Cc: Simon Davis; Paul Cann
Subject: RE: 97 Barnham Road, Eastergate - EG/107/17/DOC

We have reviewed the documents you have provided and have the following comments:

Number
S17-03-01 E

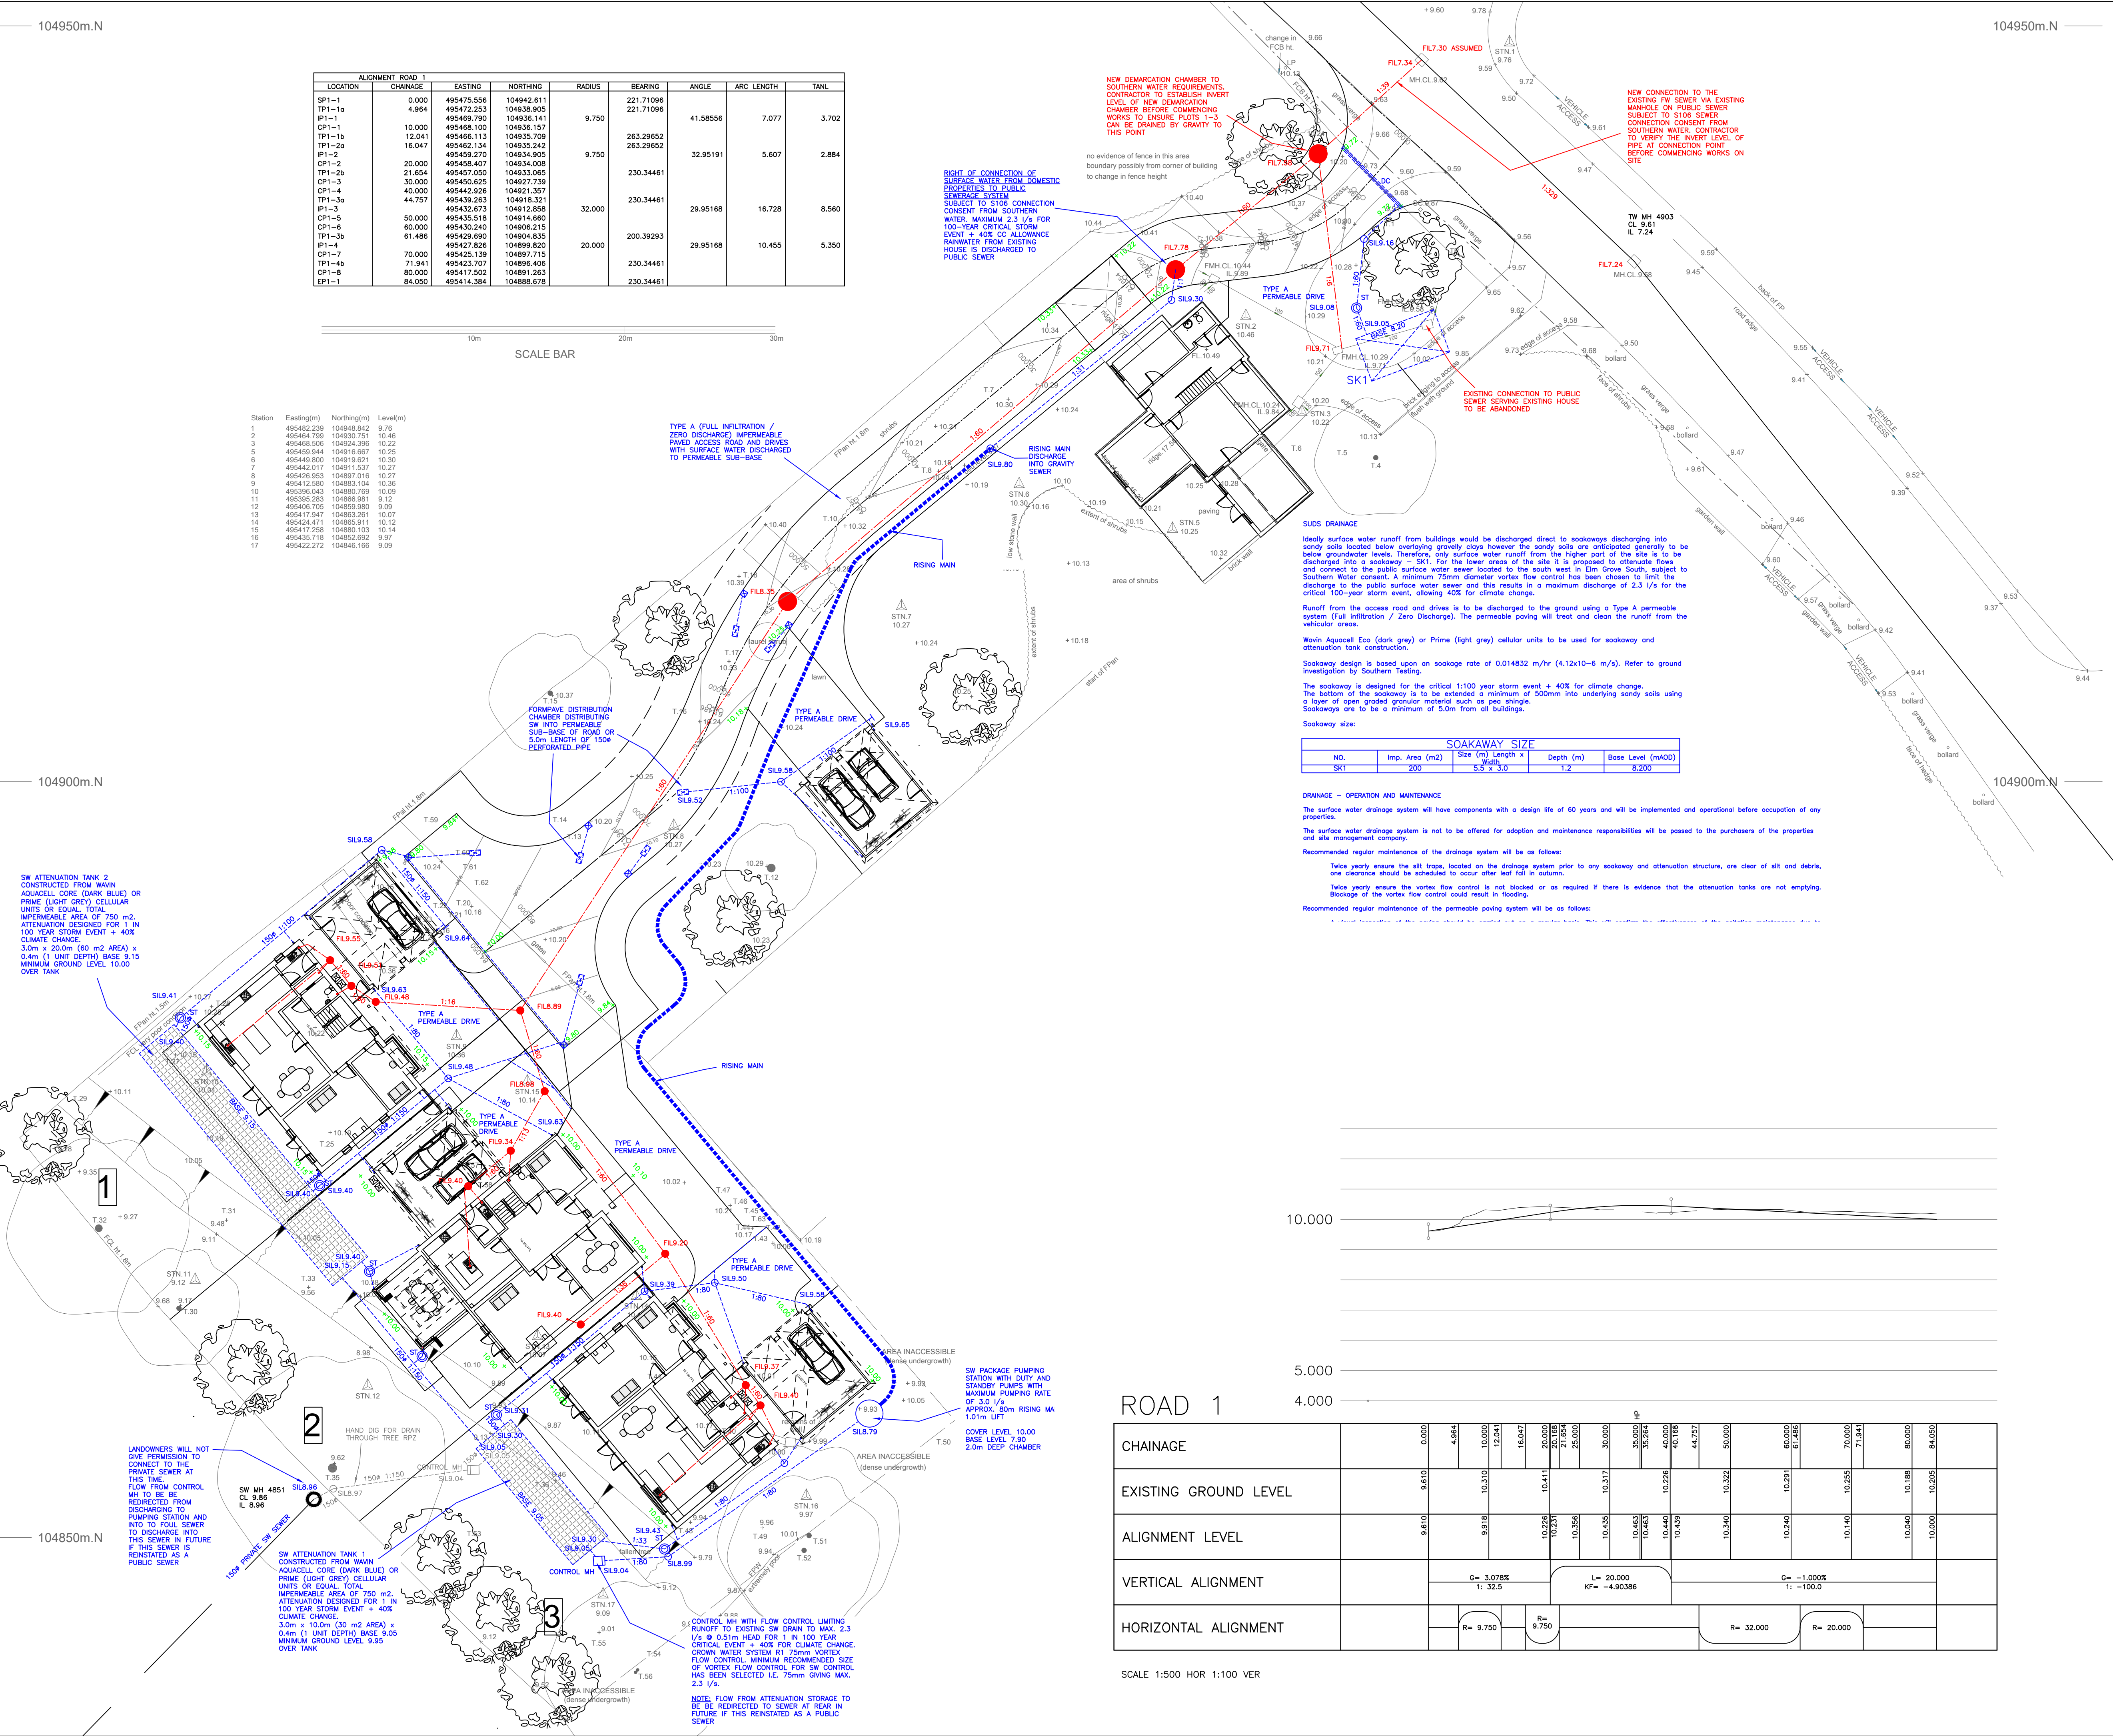
- Thrust blocks need to be provided on the rising main.
- Where the depth of the rising main is less than 0.9m we require the pipe to have a concrete bed and surround or concrete protection slab to be provided.
- A discharge manhole needs to be provided a minimum of 10m from the connection to the foul water main. With a length of gravity main in between at a suitable gradient, with a vertical back drop if greater fall is required.
